Our Ref: KFOR 17/102

**Kings Forest Stage 1, MP08-0194 MOD6 Response to Submissions**

**Figure 2:** Site Plan Precinct 1

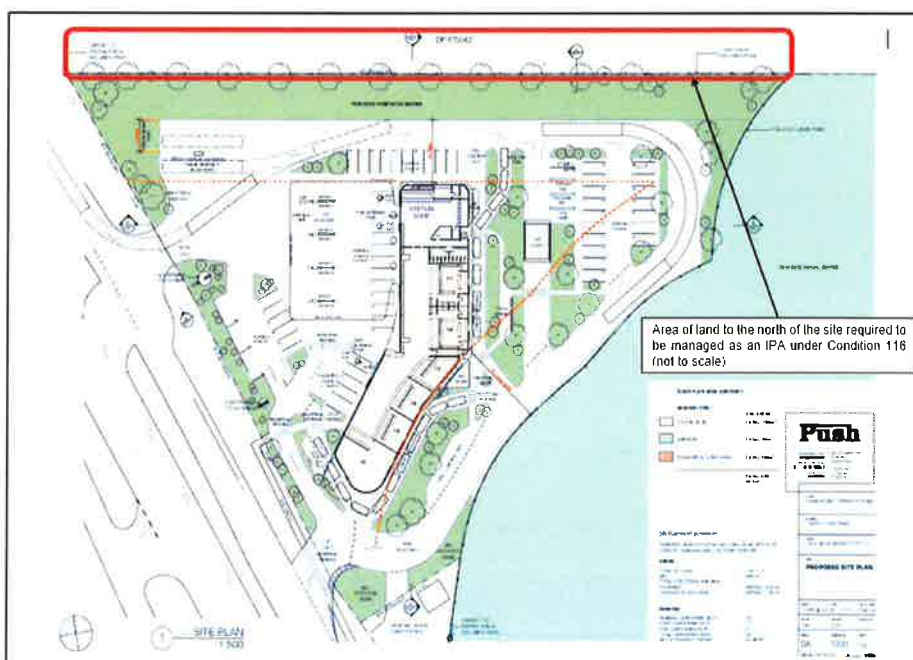
*"Council has no issues with the change in wording to Condition 116 as proposed by the amendment to the previously approved wording (Mod 3) in relation to the bushfire inner protection area description. The wording is however still cumbersome."*

Council also recommended that any plantings in the development envelope should be in line with the RFS requirements for an IPA vegetation structure as detailed under A2.2(vi) of Planning for Bushfire Protection 2006.

Following Council's comments, the Department sought further comments from the RFS. On 23 November 2017 the RFS advised that their comments regarding MOD3 in their letter dated 23 January 2017 are still relevant to the proposed site layout. However, the RFS advised that if there is still confusion regarding the wording of the condition this could be resolved by a specific plan showing the area of the proposed APZ.

The proposed modified Condition 116 was prepared following advice from the DoPE. The approved Site Plan (Push, Drawing No. 1000, Issue P3, December 2016) shows the Koala exclusion fence on the eastern side of the site and the proposed condition refers to this Plan, which clearly shows the entire area northwest of the Koala exclusion fence.

It is considered that the proposed wording of Condition 116, which has been prepared following advice from the DoPE and is endorsed by the RFS, is not confusing and does not require a specific plan or further amendment.
